From: Sarah Burrow <Sarah.Burrow@arun.gov.uk>
Sent: 19 November 2019 14:46
To: Planning.Responses <Planning.Responses@arun.gov.uk>
Cc: Anita Gardner <Anita.Gardner@arun.gov.uk>
Subject: RE: Planning Consultation on LU/337/19/DOC

Engineers Comments Regarding Surface Water Drainage

APPLICATION NO: LU/337/19/DOC

Description of Works: Application for approval of details reserved by conditions imposed on planning permission LU/205/16/PL relating to condition 6 & 12 - soakaway design alternative & soakaway design calculations

DRAWING TITLE
SOAKAWAY DESIGN ALTERNATIVE TO PERMEABLE PAVED INFILTRATION SYSTEM

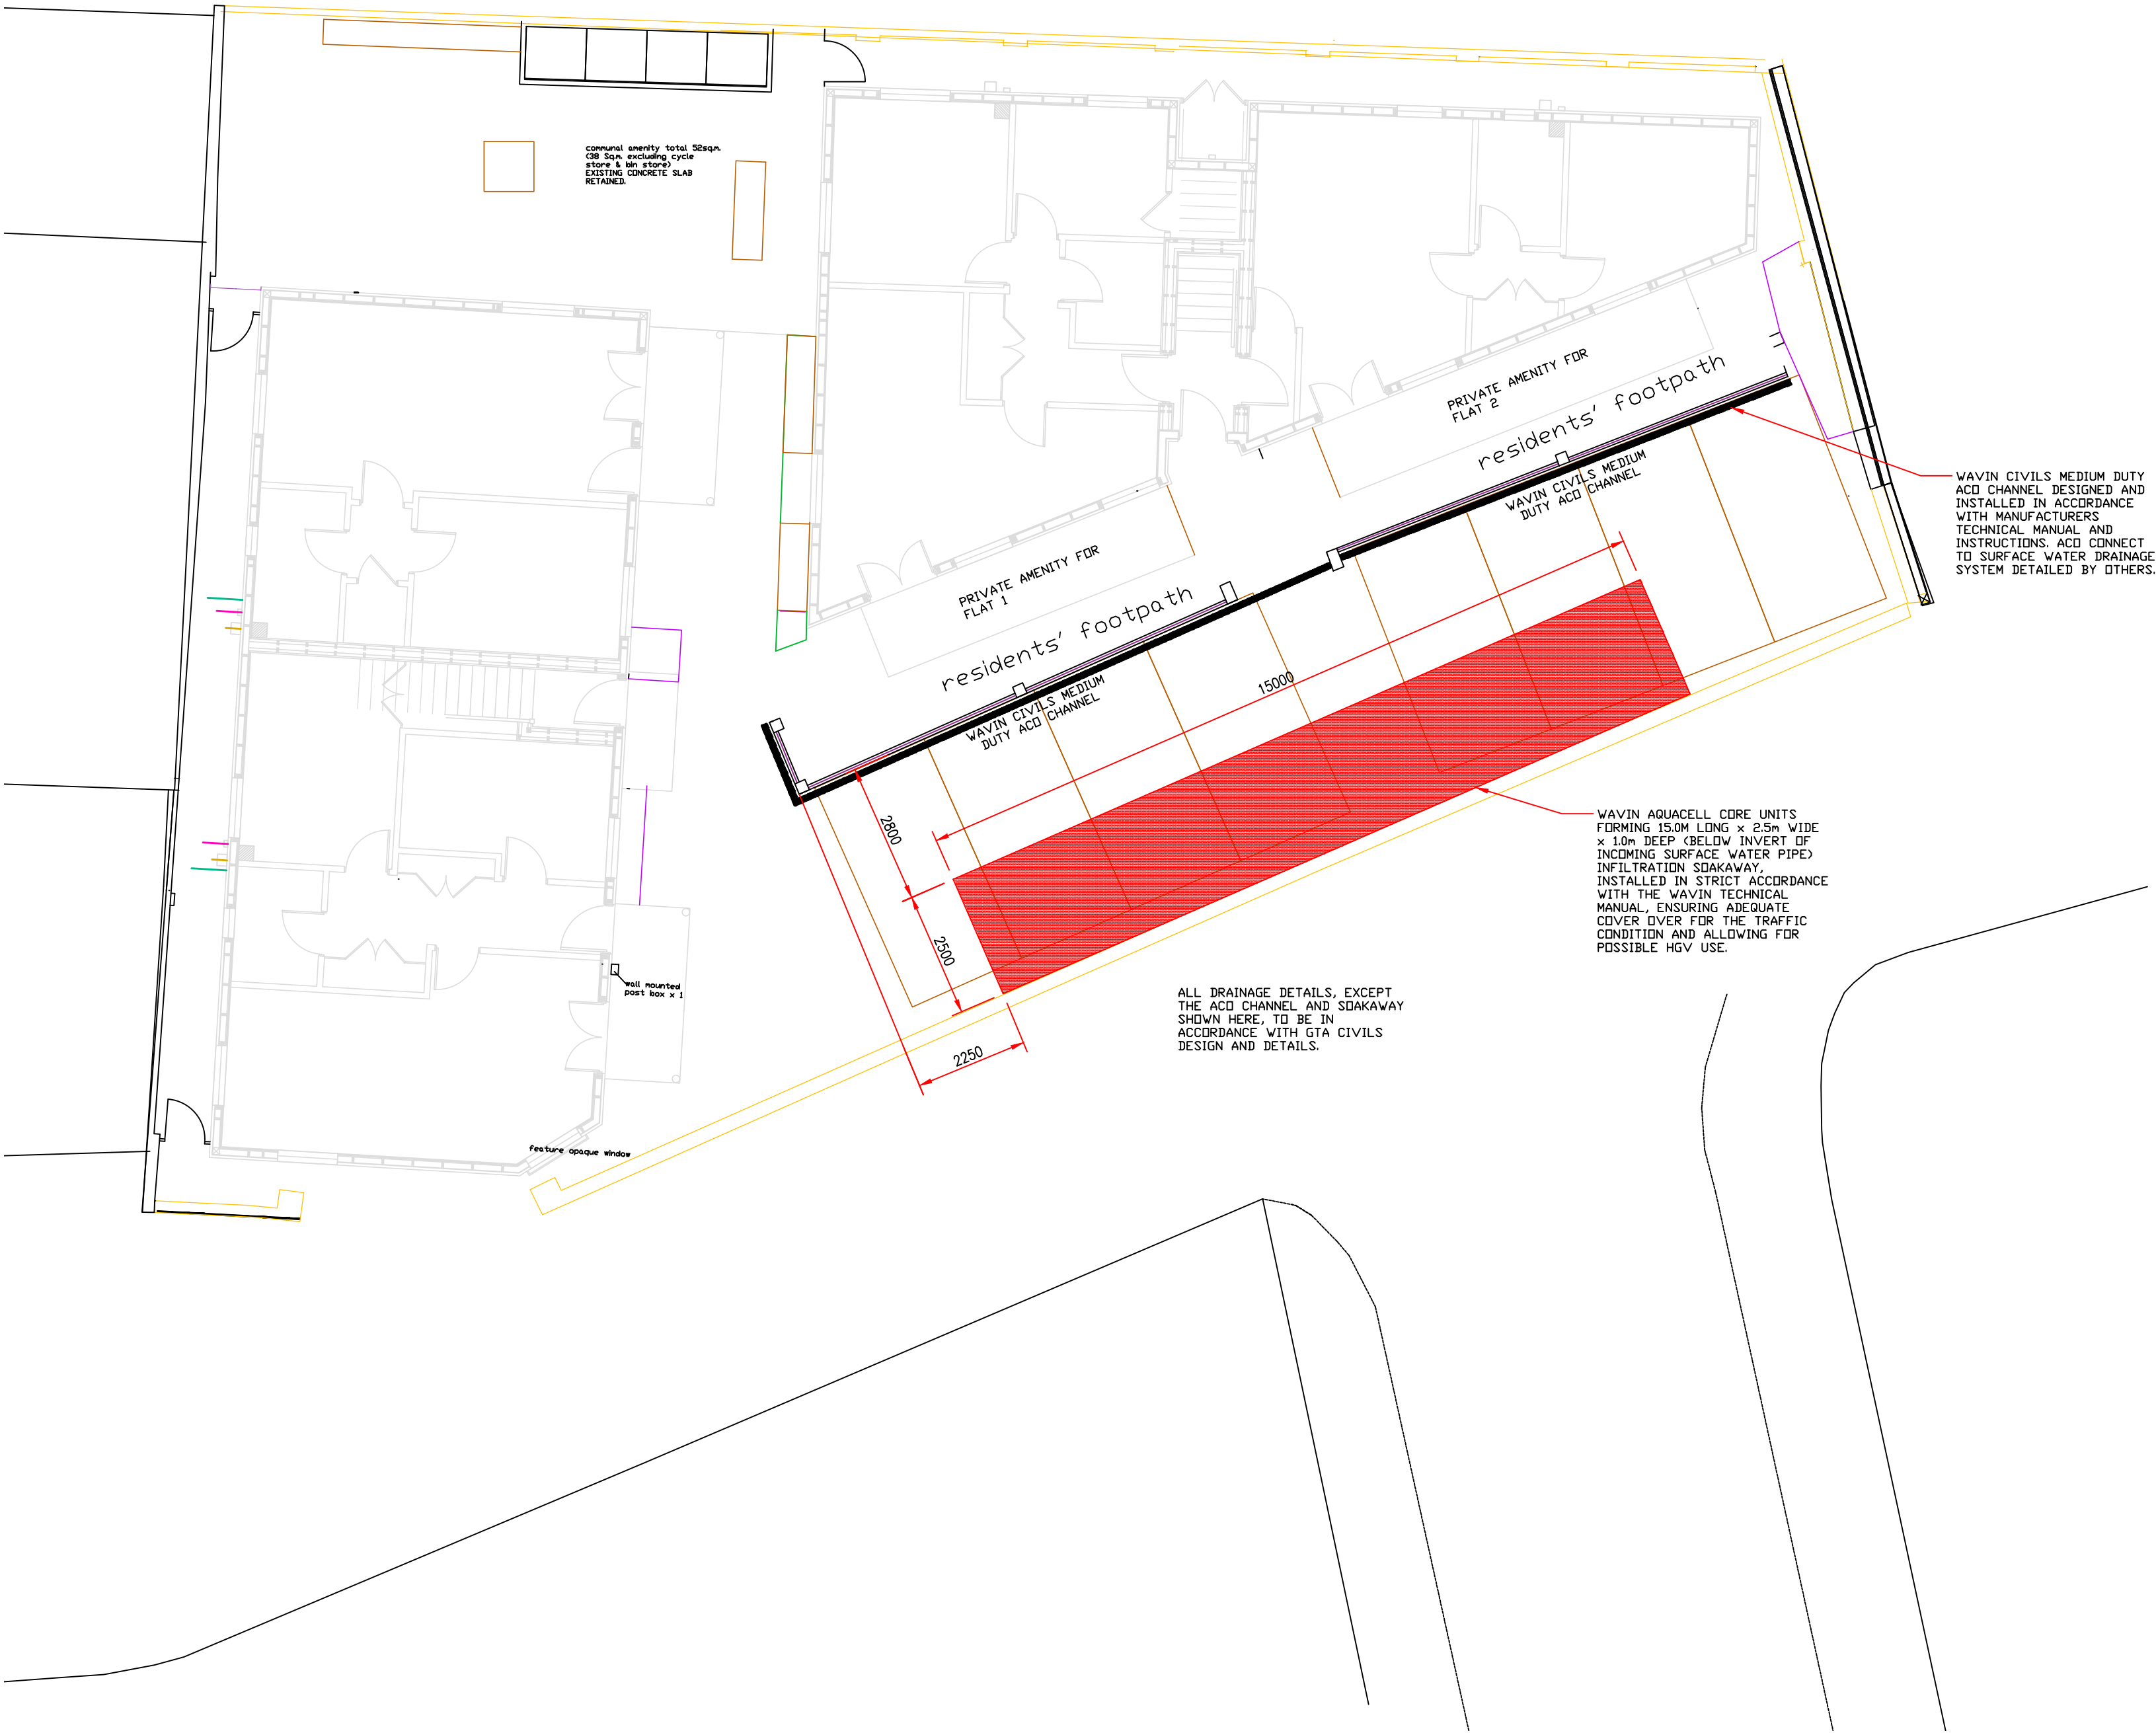
1. Please provide details of infiltration testing and groundwater monitoring. Including the depth that the infiltration tests were completed to. The proposed soakaway is deeper than the agreed permeable paving.
2. Please submit drawing details for the soakaway and ACO channel, including the appropriate cover depths and levels.
3. Please include the location of pipes and manholes on the Drainage Layout, please label these with their diameters, materials, cover levels, invert levels and falls as appropriate.
4. The calculations have confused the dimensions of the soakaway. The depth is 1m (1000mm) rather than 14776mm. Please adjust accordingly.
5. Please add 40% allowance for climate change.
6. Please provide silt traps upstream of the connection to the soakaway and show these on the drainage layout.
